**KIRKLEES METROPOLITAN COUNCIL
INVESTMENT & REGENERATION SERVICE**

Reference No:	2024/62/93319/W
Site Address:	418A, Wakefield Road, Dalton, Huddersfield, HD5 9XJ
Description:	Raising of roof and erection of front and rear dormer extensions and alterations
Recommending Officer:	Joanna Rednall

HOUSEHOLDER DELEGATED REPORT

Proposed front/north facing elevation (1:100)

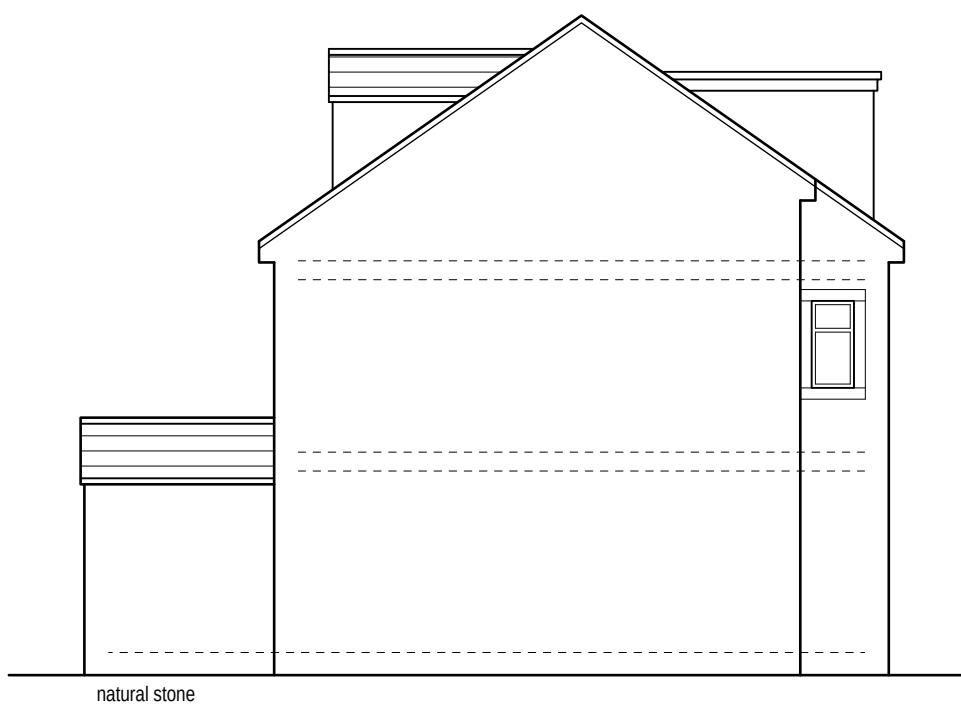
rear dormer would have an acceptable visual impact in this case.
Be designed in style and materials similar to the appearance of the existing house and roof	The submitted plans outline the proposed dormer front and cheeks would be grey horizontal pvc cladding. To ensure the dormers have an acceptable visual impact, the proposed materials can be conditioned to match.	
Not dominate the roof or project above the ridge of the house	Both front and rear dormers are set within their respective roof planes and would not project above the ridge of the house. The rear dormer is larger in scale than the front dormers, however a sufficient level of space is retained around the rear dormer to not dominate the roof slope.	
Be set below the ridgeline of the existing roof and within the roof plane	The dormers are set below the ridgeline.	
Be aligned with existing dormer windows on neighbouring properties in the same roof plane where relevant	Front dormers are not an established design feature on properties surrounding 418A, Wakefield Road, however neighbouring dwellings vary in terms of design, therefore the introduction of two small front dormers would not appear incongruous within the street scene. The existing property has a small gable feature to the front elevation, the removal of this feature

and insertion of two dormers would not have a significant visual impact. The windows would be aligned with existing openings on the ground and first floor.	
--	---	--

4. The external walls of the dormers hereby approved shall be first installed with Anthracite grey horizontal UPVC cladding to harmonise with the existing roof tiles. The pitched roof of the front dormers shall be laid with concrete interlocking tiles to match the host dwelling. The cladding and roofing materials so approved shall thereafter be retained.

Proposed rear./south facing elevation (1:100)

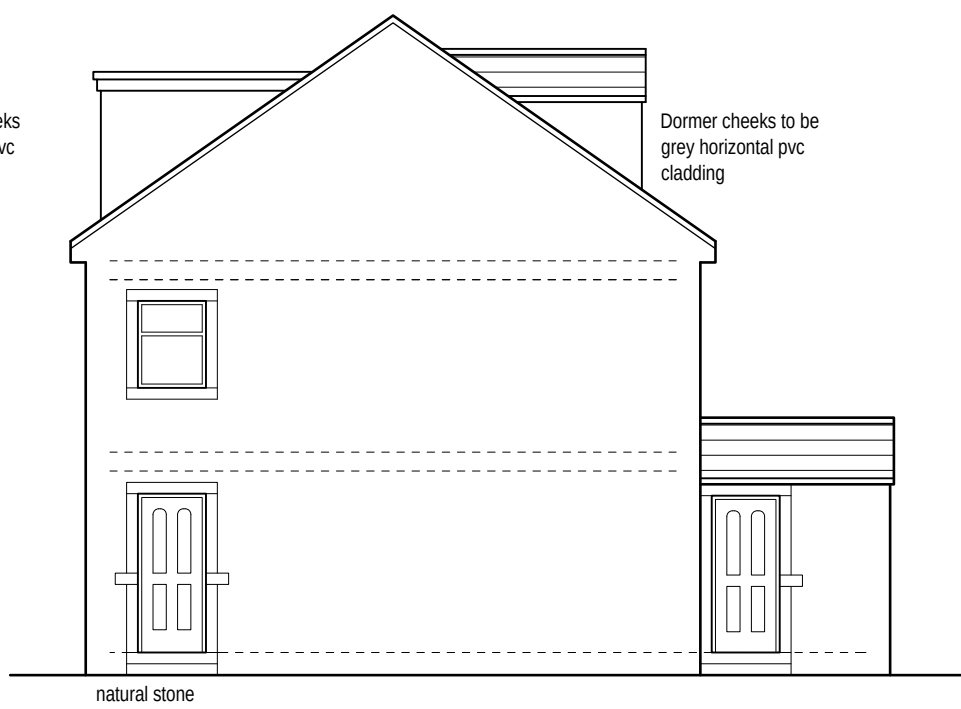
occupiers at No.2. Following submission of amended plans, the rear dormer windows are obscurely glazed. Although two of the three of these windows serve bedrooms, the rear dormers would be secondary windows, therefore to protect the amenity of occupiers at No.2 a condition is necessary to ensure these rear dormer windows would be obscurely glazed.

Overlooking	Amended plans have been received showing the rear dormer windows to be obscurely glazed.	✓
-------------	--	---

5. The development shall not be occupied until the windows in the rear dormer hereby approved have been obscure glazed minimum grade 4. The obscure glazing shall thereafter be retained for the lifetime of the development.
